EPC STORMWATER REVIEW COMMENTS
IN ORANGE BOXES WITH BLACK TEXT

KINCH SUBDIVISION

Grading & Erosion Control Plans

JANUARY 2022

GEC TITLE SHEET

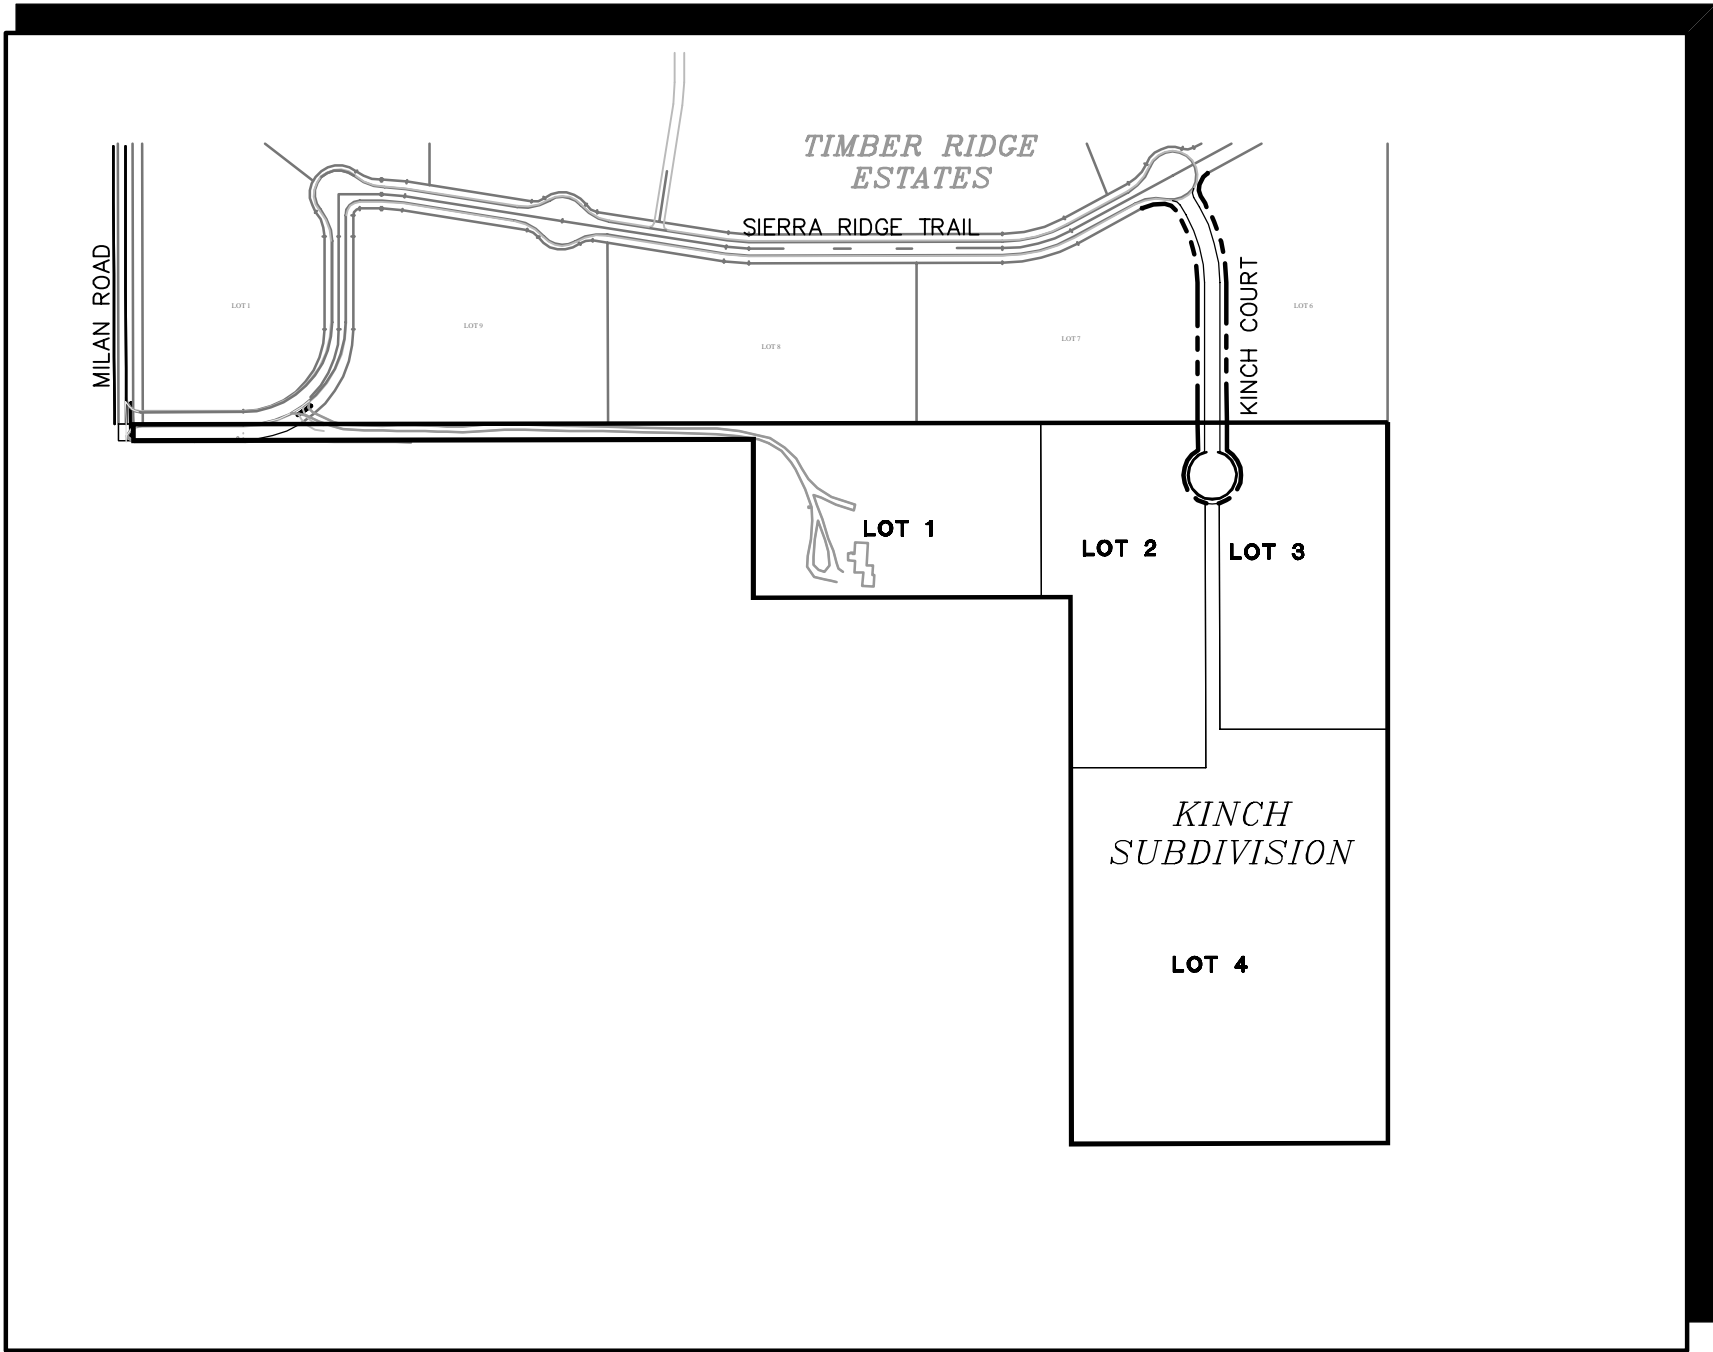
Add text:
PCD Filing No.:
MS224

revise to match Item "ff"

insert the 3rd paragraph
shown on Item "jj"

GRADING & EROSION CONTROL PLAN

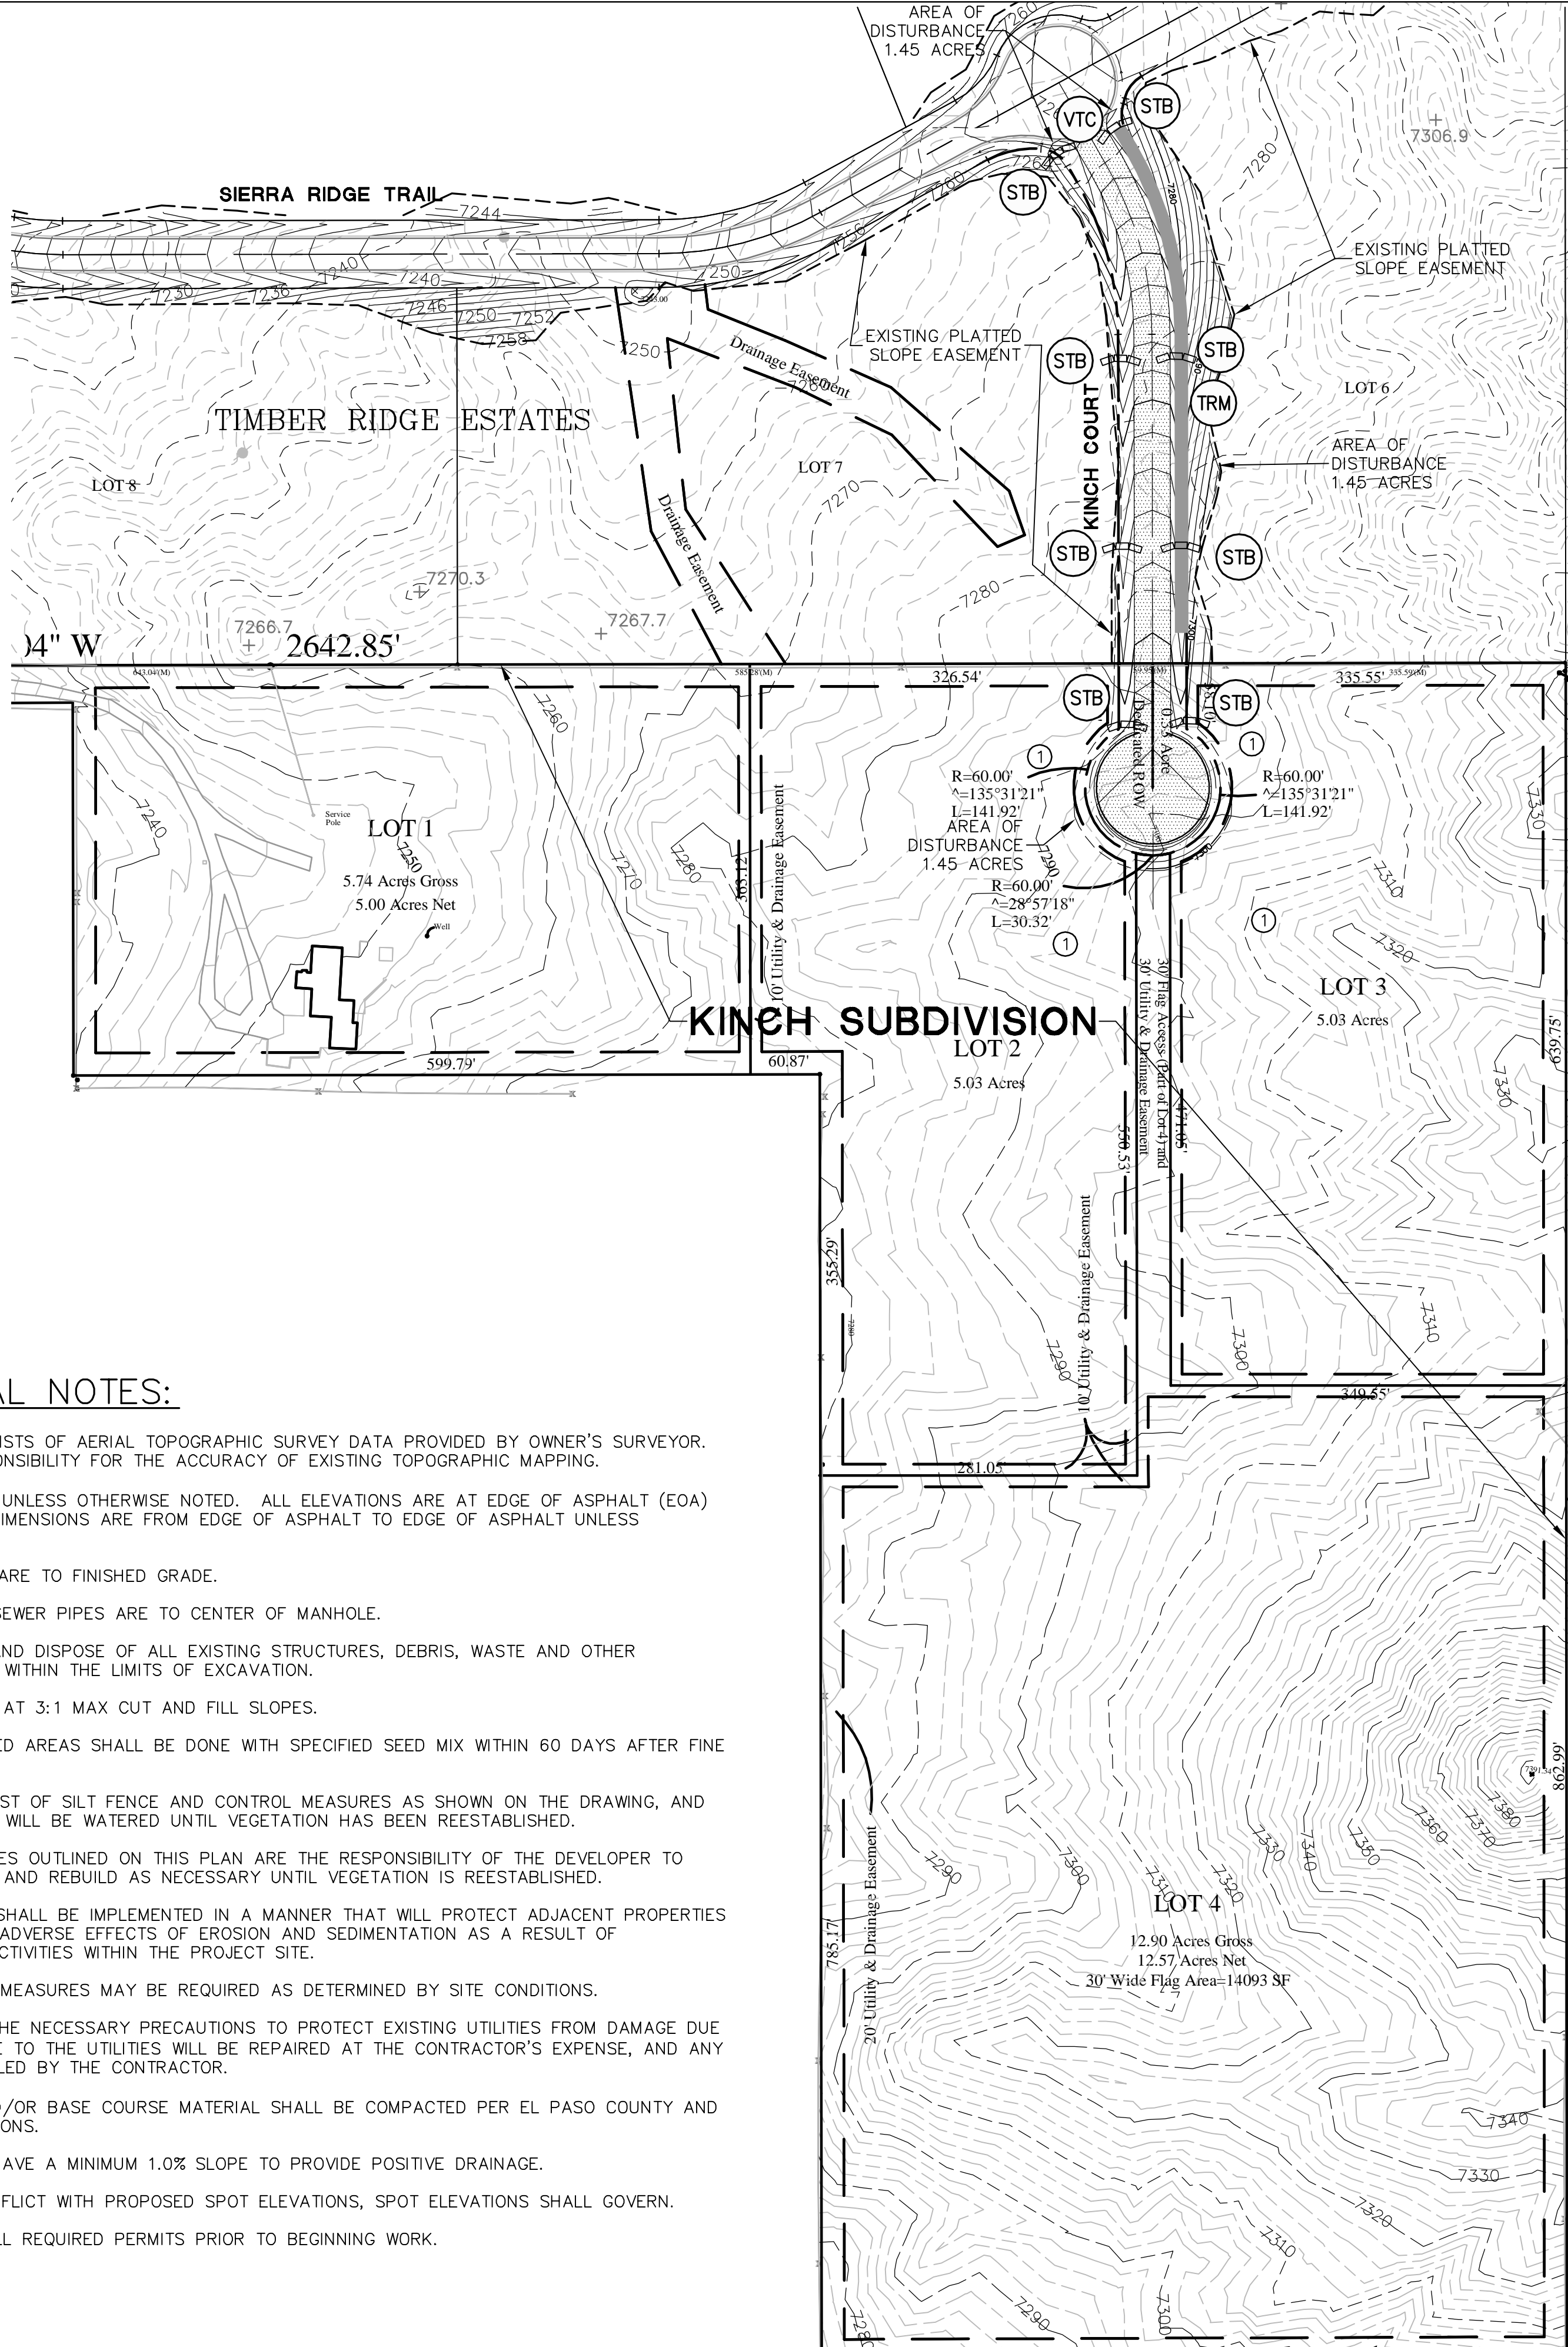
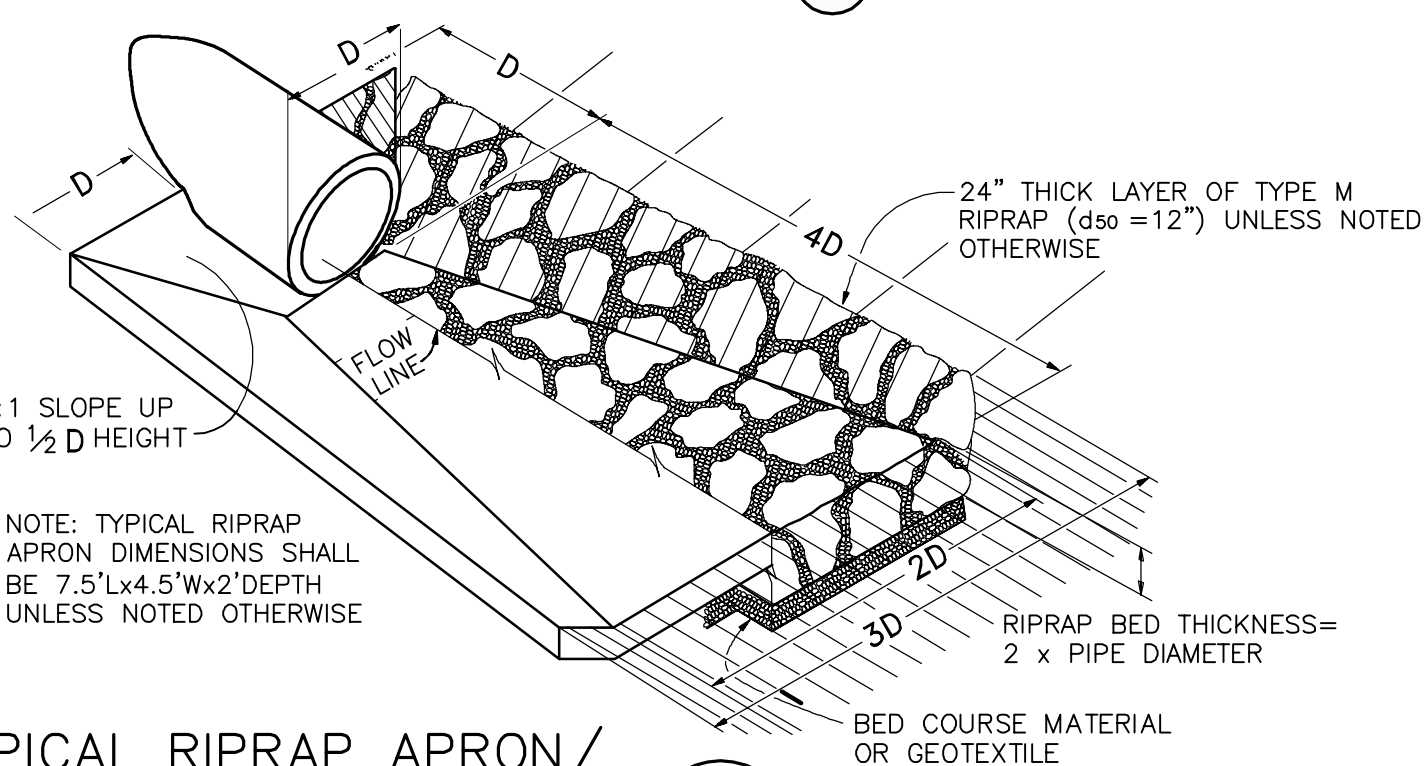
Item 'p' - delineate areas of cut/fill and/or make a macro-level note about general locations of cut/fill.

Show flow direction arrows within the LOD and outside the LOD.

- Extend viewport to show tie-in from proposed to existing and show entire LOD.
- Show BMPs in ditch.
- Show existing driveways and subsequent existing or proposed culverts and associated BMPs.
- label grade of steeper slopes onsite.
- Show existing driveways and existing or proposed driveway culverts.

Right now construction drawings and grading and erosion control plans do not match. Sierra Ridge Trail is included in the limits of disturbance/construction. Is grading on Sierra Ridge Trail part of the project scope?

show location on plans.

Remove not-used (or at least not expected) BMPs from Phasing Plan.
